From: Longridge Town Council <clerk@longridge-tc.gov.uk>
Sent: 18 June 2018 21:04
To: planning
Cc: clerk@longridge-tc.gov.uk
Subject: PLANNING COMMENTS FROM LONGRIDGE TOWN COUNCIL

Please see below comments from Longridge Town Council:

3/2018/0341 The application is for the erection of long cabins and camping pods on agricultural land and formation of new access and track to service them at **The Brows Farm Brows Barn Higher Road Longridge PR3 2YX**

Drawing Title
PROPOSED SITE PLAN

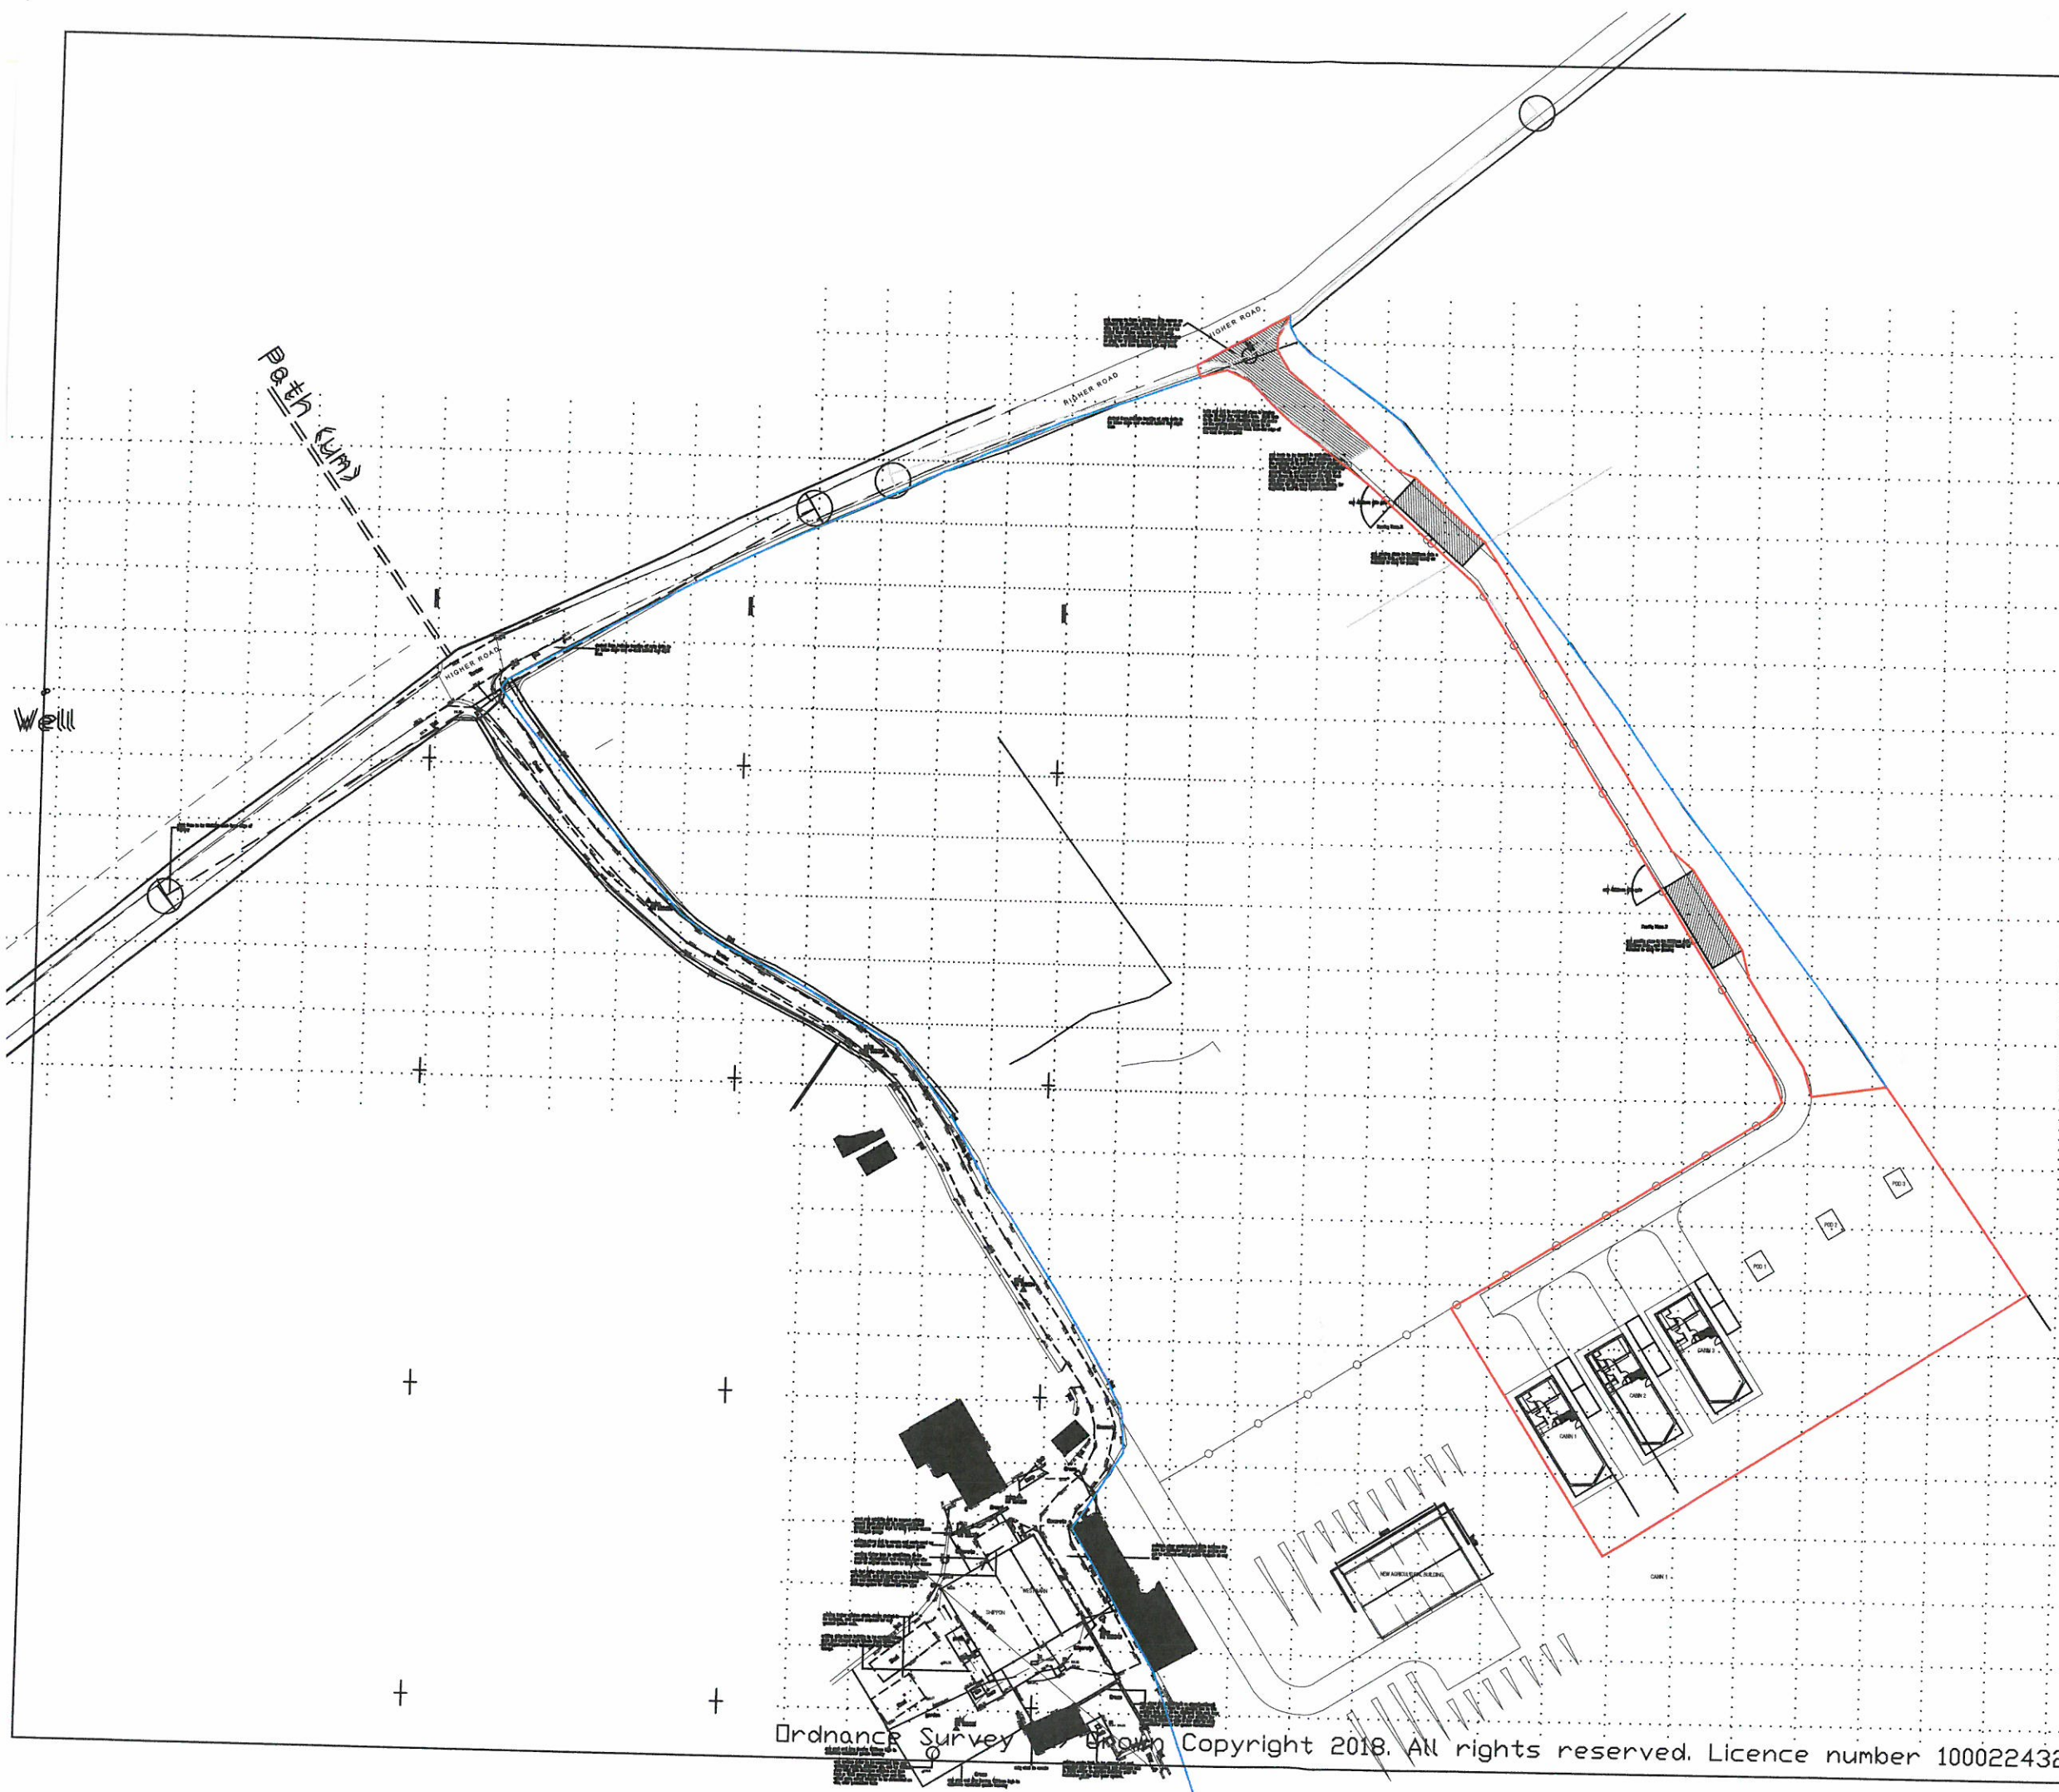
2 - The sighting of the dwellings so the ridgeline is not broken

3- Propose Screening is used

Drawing Title
 PROPOSED ELEVATIONS

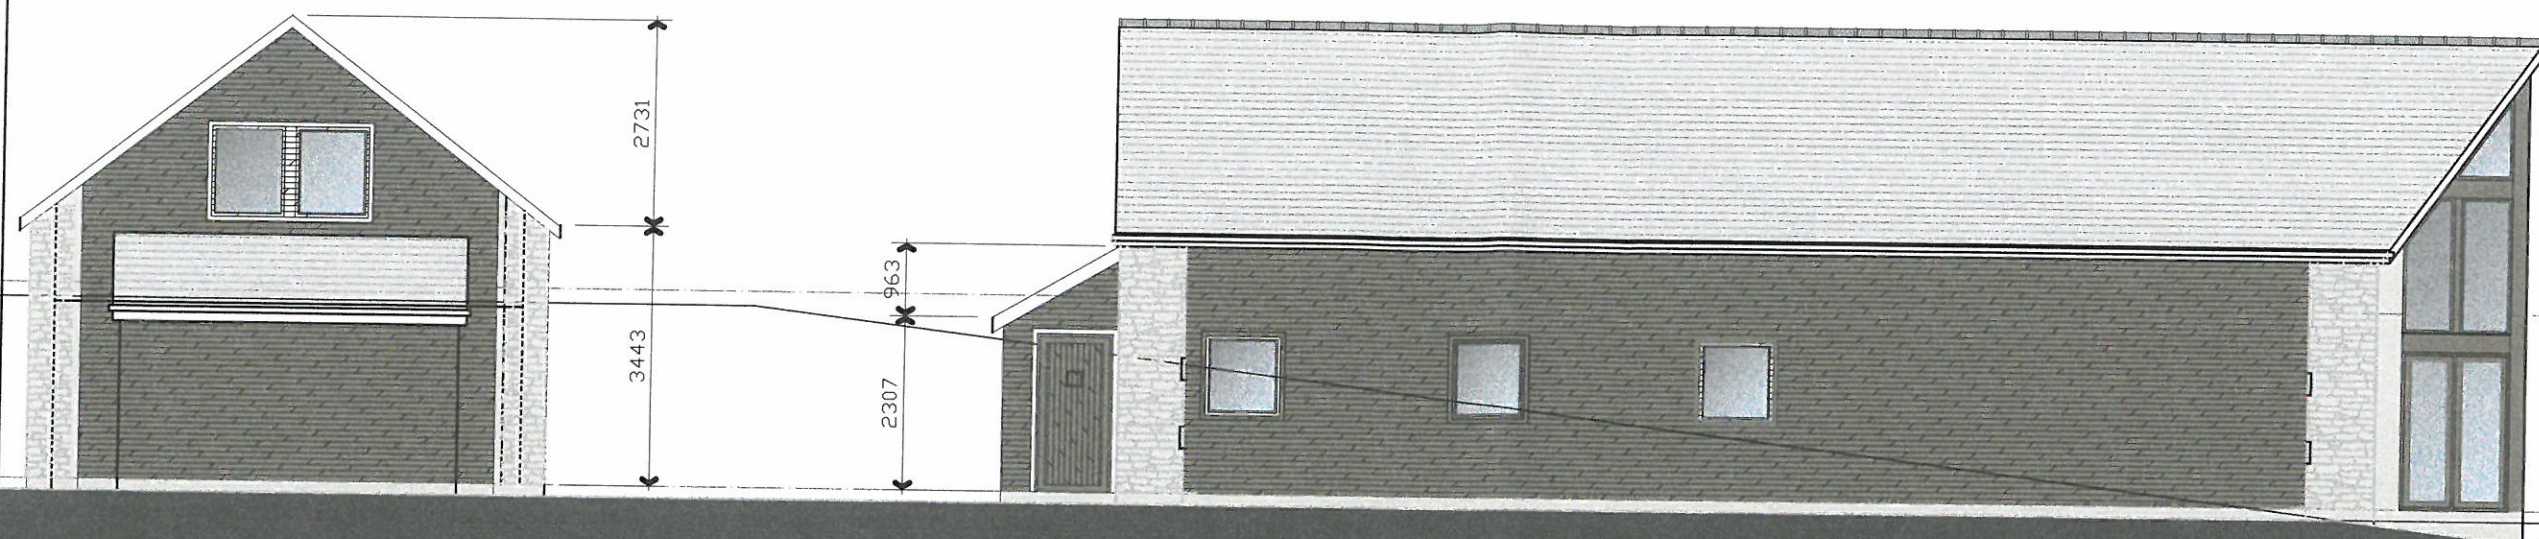
1 - The necessity for the two storey element of the accommodation
